29 July 2021

I am writing in answer to the Planning Application , Number 3/2021/0725, grid reference 375940 445483. My property is [REDACTED] The Buck Inn.

6239 - P02 REV B

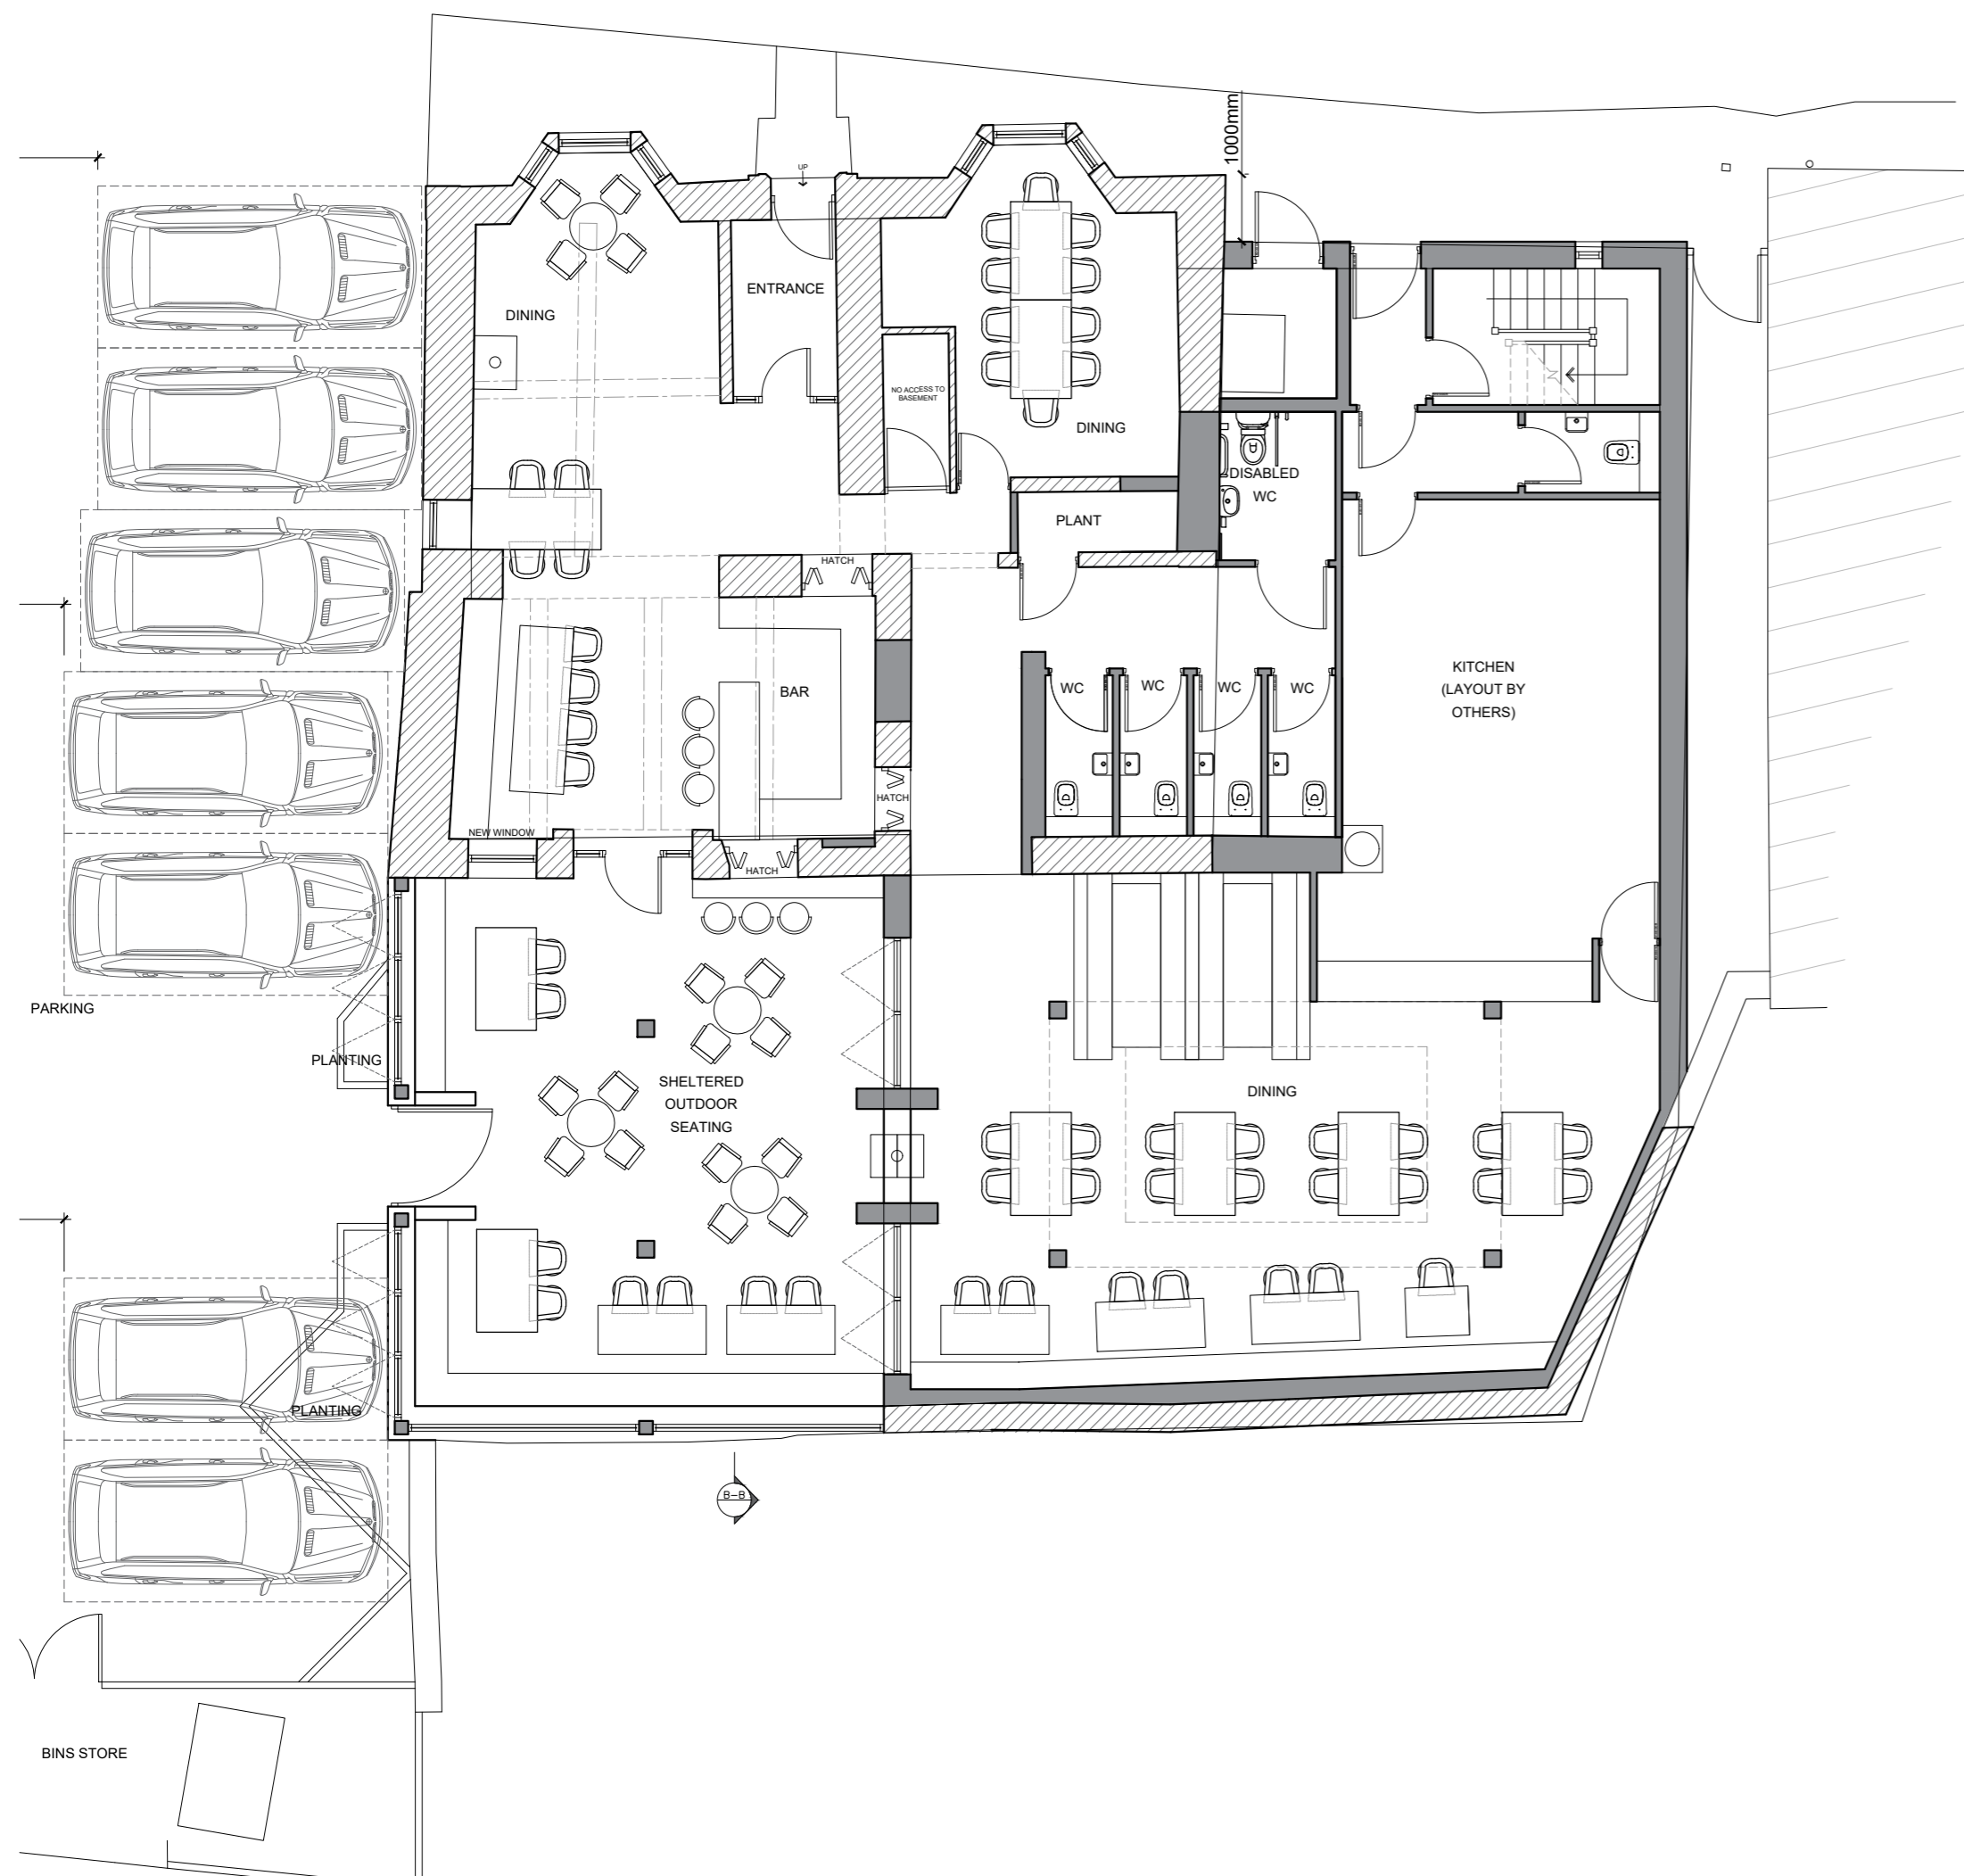
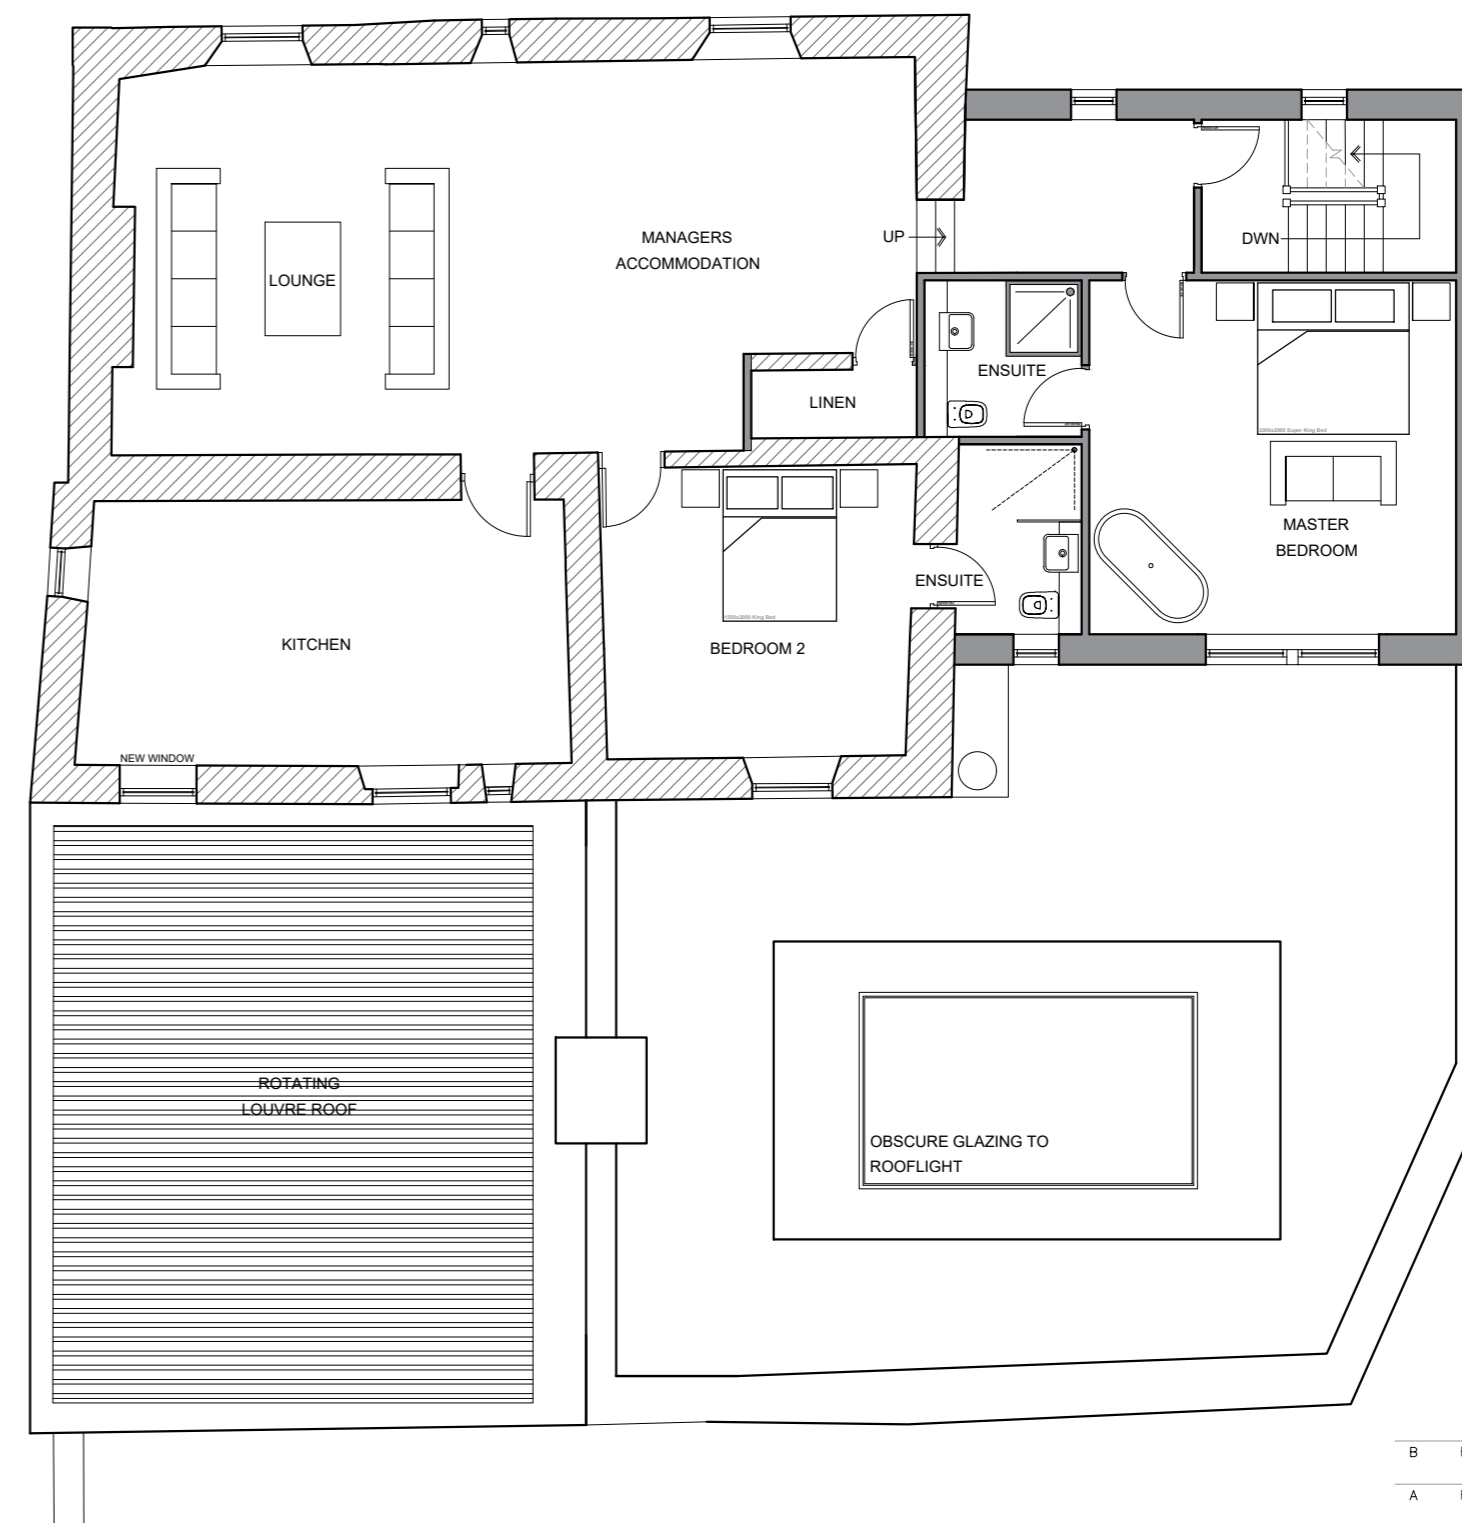
[REDACTED] This allows access [REDACTED] and, more importantly, to the gate at the rear of the car park to a number of other properties. I am concerned the space allotted for manoeuvring six cars is too small. In addition the plans clearly show that the owner is intending to increase the number of tables, thus expecting considerably more than six cars. This leads me to suspect that there will be many more cars parked on the street where many cars are parked already. I insist that no cars should be parked [REDACTED] because this would cause a traffic hazard when cars exiting Main Street [REDACTED] would impede cars coming both ways along Sawley Road.

Finally, I am rather concerned about the intended plans to turn the upper storey into four bed and breakfast rooms. Will there be no access from these to the bar? Otherwise, it might be that some groups might use them for all night drinking parties, again unsuited to a quiet residential area. I gather there will be no one on site to supervise or help the guests.

PROPOSED SITE PLAN SCALE 1:100

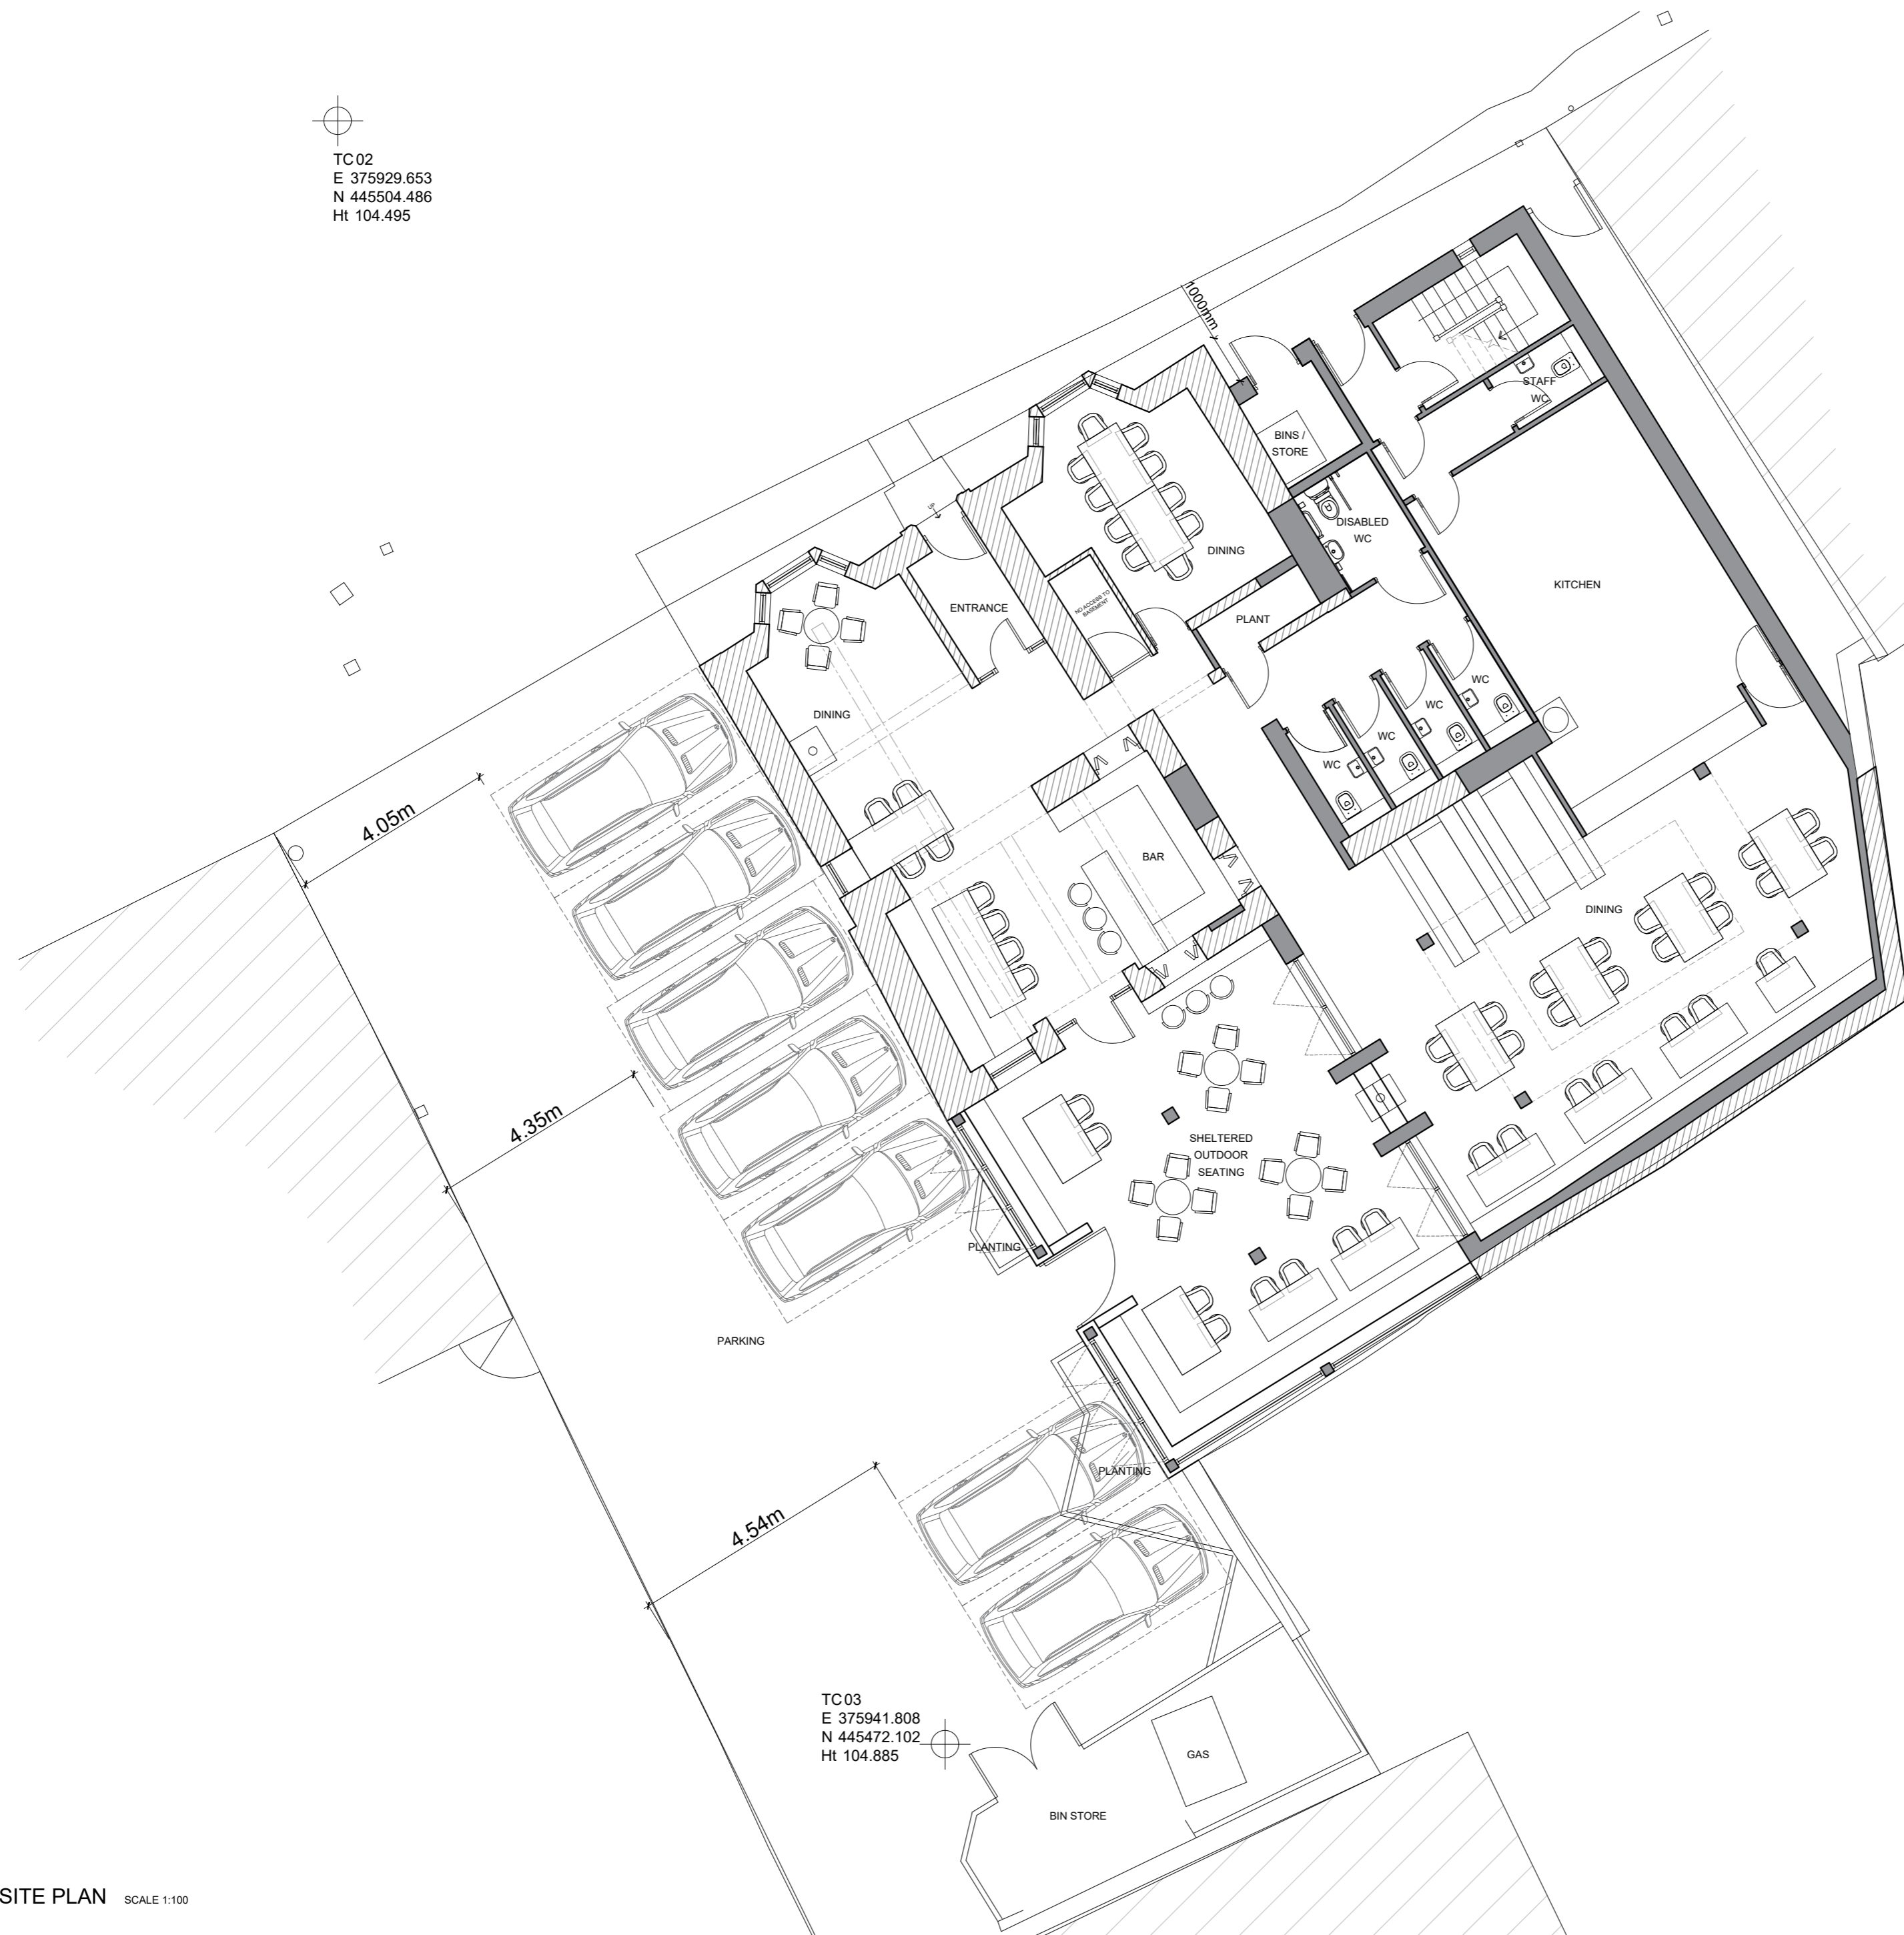
The plans show spaces for six cars parked in a herring bone fashion at the side of the Buck in the car park which [REDACTED] I am concerned that these need to be very clearly delineated [REDACTED]
